Our ref: HE551507-MMSJV-LSI-000-CO-UU-0004

30 April 2019

A303 Sparkford to Ilchester Dualling Development Consent Order - Non-material change request

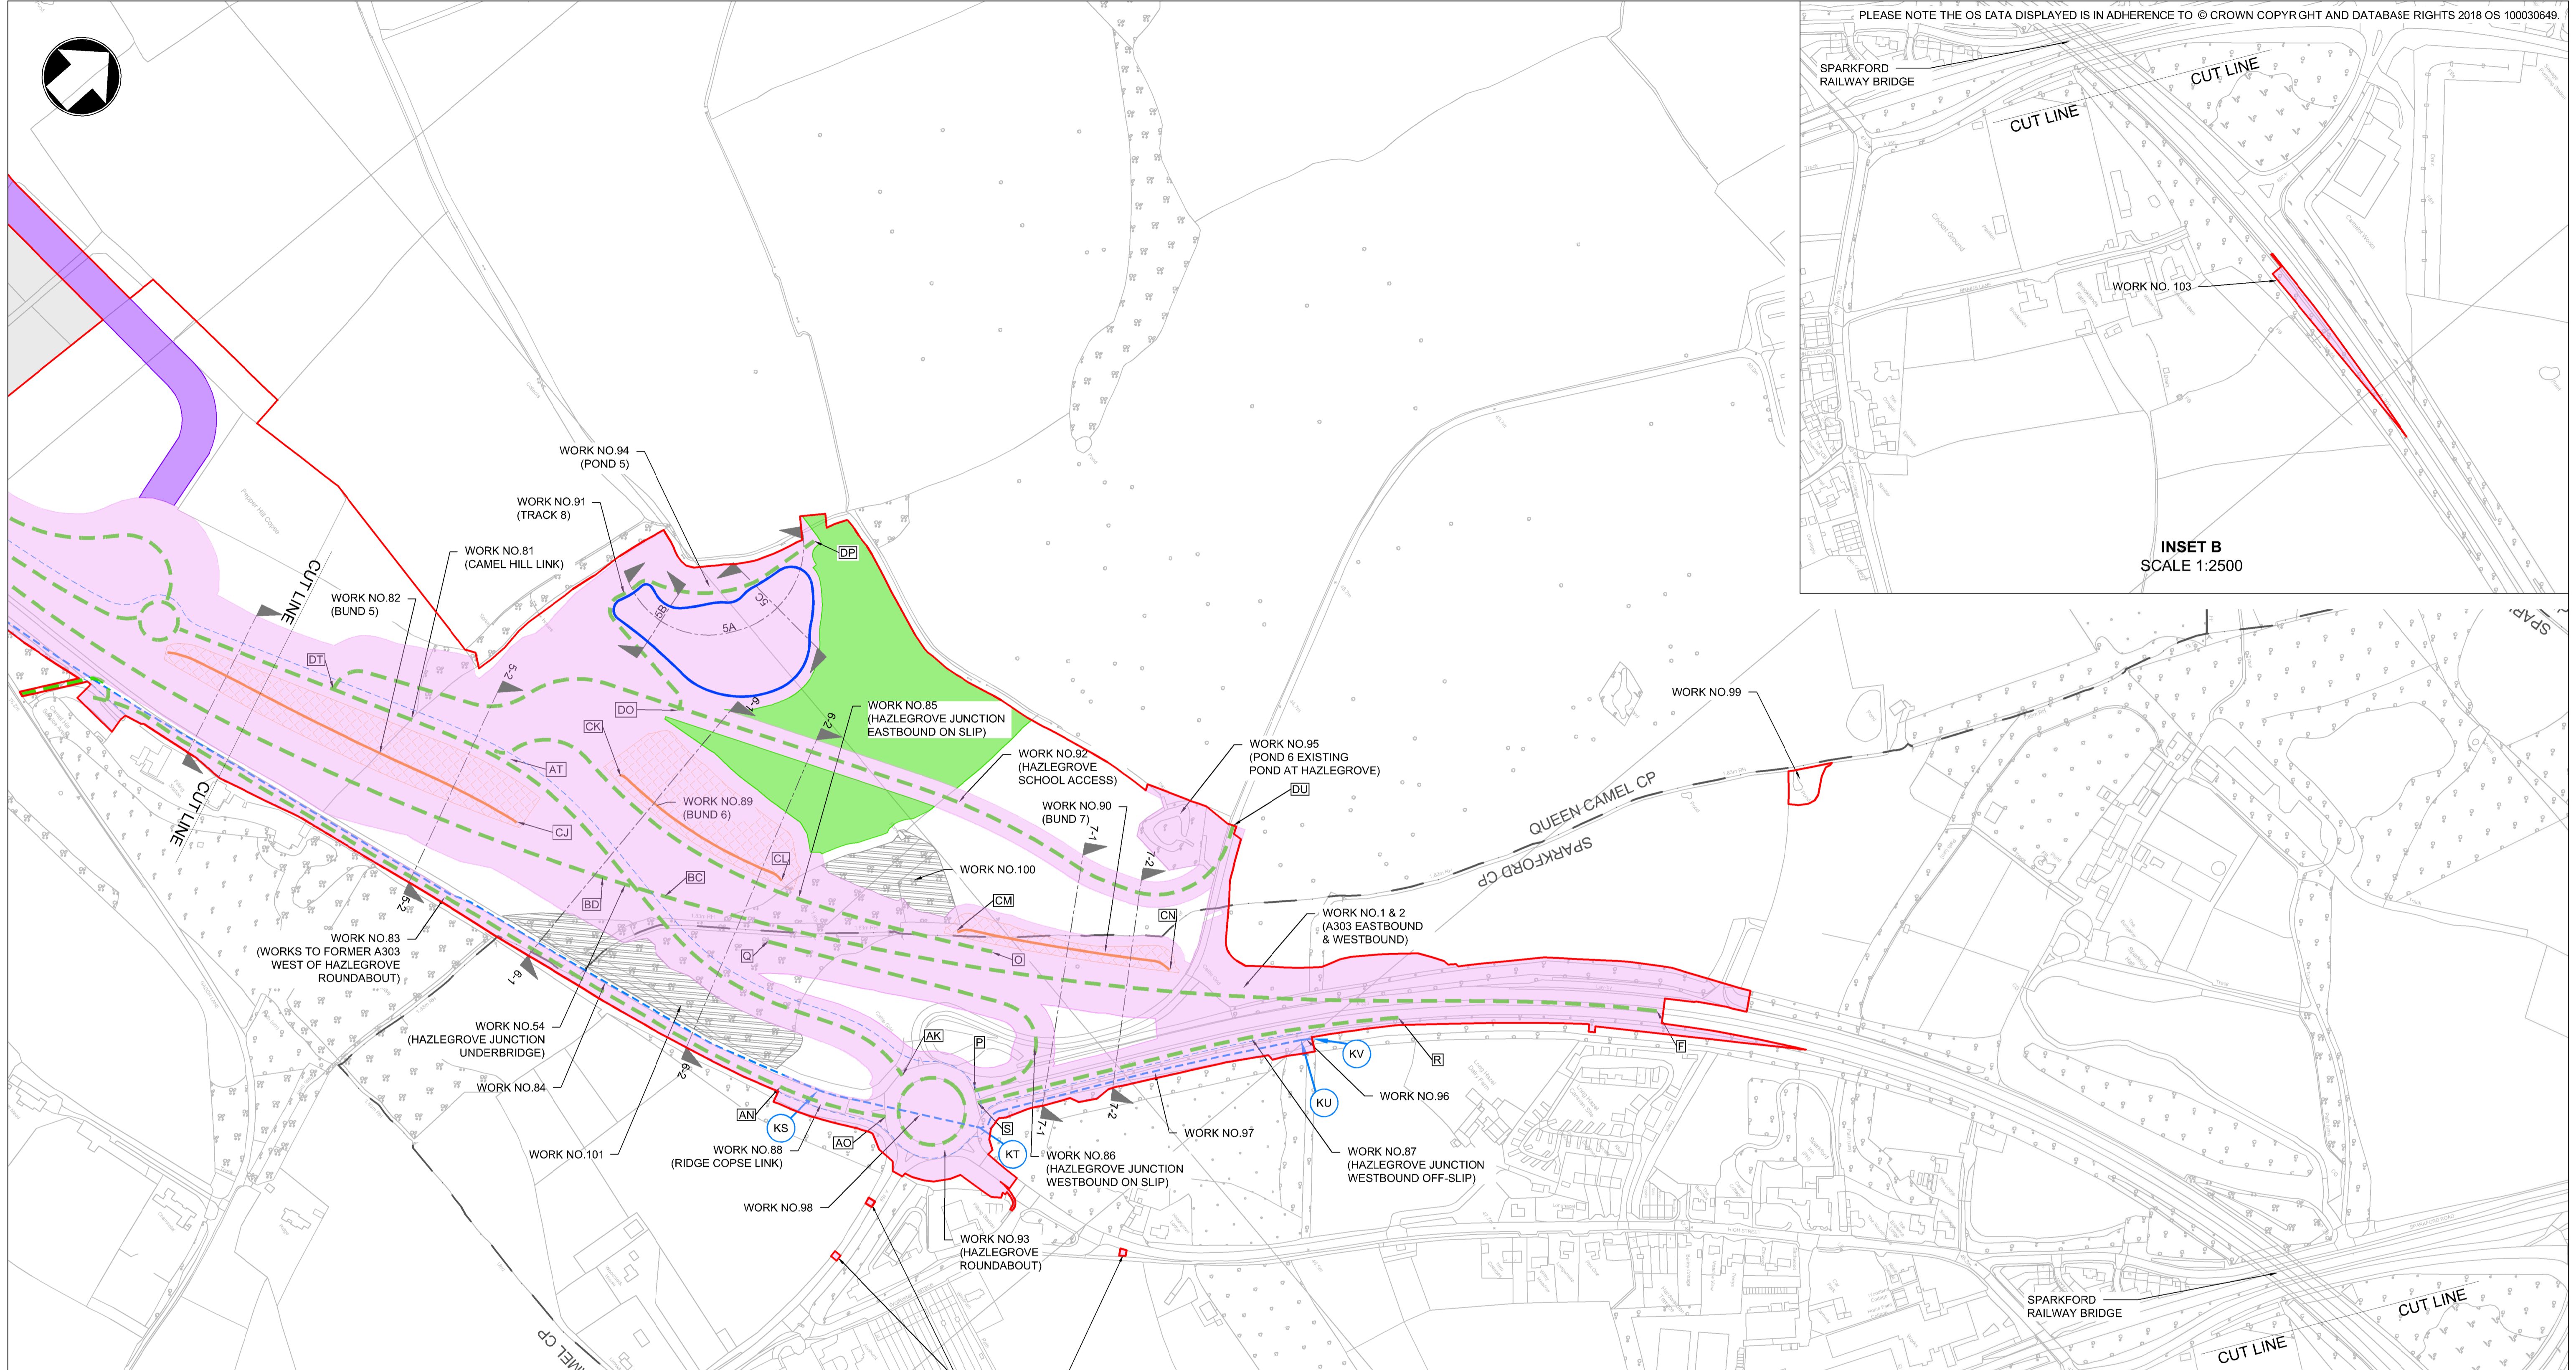
The Applicant has been in discussions with Historic England and South Somerset District Council in relation to the design of Pond 5, which is located within the RPG. In order to address concerns raised by those parties, the Applicant proposes to relocate Pond 5 slightly south and west, further into the corner of the RPG. The Applicant also proposes to realign the maintenance track for Pond 5 to follow the western perimeter of the pond, resulting in the eastern perimeter fence of the Pond being moved westwards by approximately 20 metres. These changes are shown on the enclosed updated Works Plans (Sheet 4).

It is proposed to realign the access to the School by moving it approximately 20 metres northwards, which has the beneficial effect of avoiding the veteran tree in this location. In order to improve the sense of arrival in the RPG the Applicant is also proposing additional planting between the realigned Pond 5 access track and the access track to Hazlegrove School. Additional woodland planting is proposed to be provided to the south west of Pond 5 so that the arrival point into the RPG is an emergence from woodland with views to Hazlegrove House. Additional screening planting in front of Bund 7 (in the form of semi-mature trees) in order to screen the environmental barrier is also proposed. The changes to the realigned access are shown on the enclosed updated Works Plans (Sheet 4).
